**From:** Brenda Larsen  
**Sent:** Thursday, March 27, 2014 12:14 PM  
**To:** Kaycee Hathaway  
**Subject:** RE: Kittitas County Notice to Agencies: BL-14-00008 Kuchin

Re: Kuchin (BL-14-00008)

BL-14-00008 Kuchin

Proposed

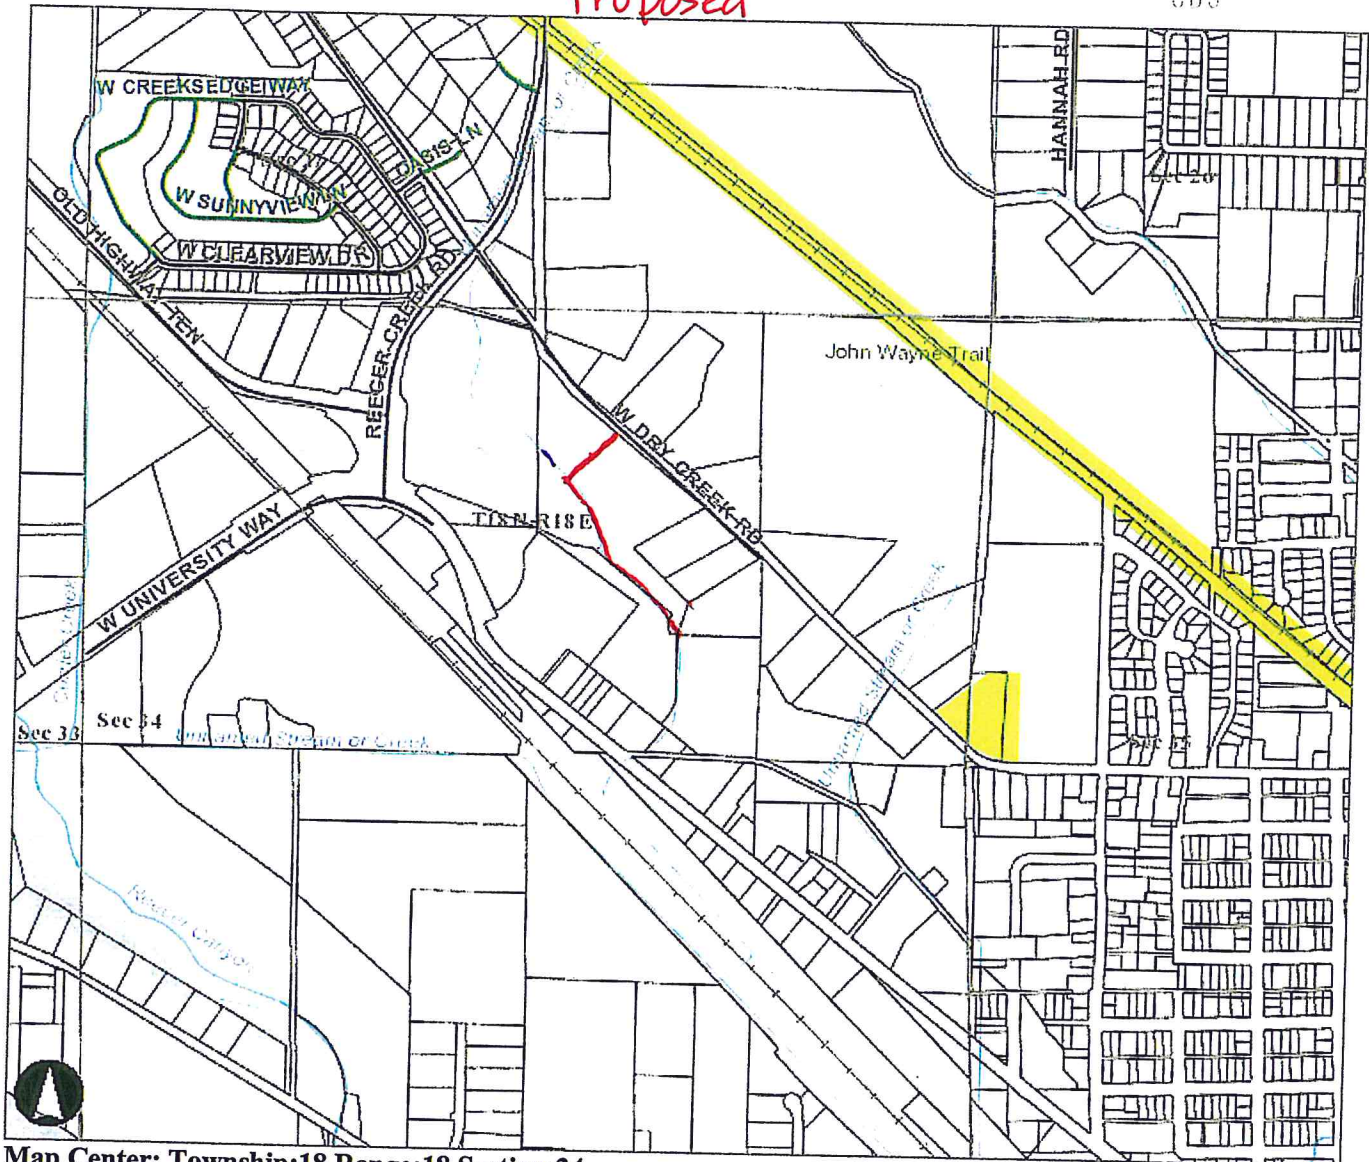
- Ensure that boundary line adjustments do not infringe upon existing structures, to include propane tanks, etc.
- Ensure adequate access for fire apparatus. Any driveways or access points created based off the new lot configurations shall comply with Kittitas County Code 20.02.030.
- All future development must comply with the International Fire Code.
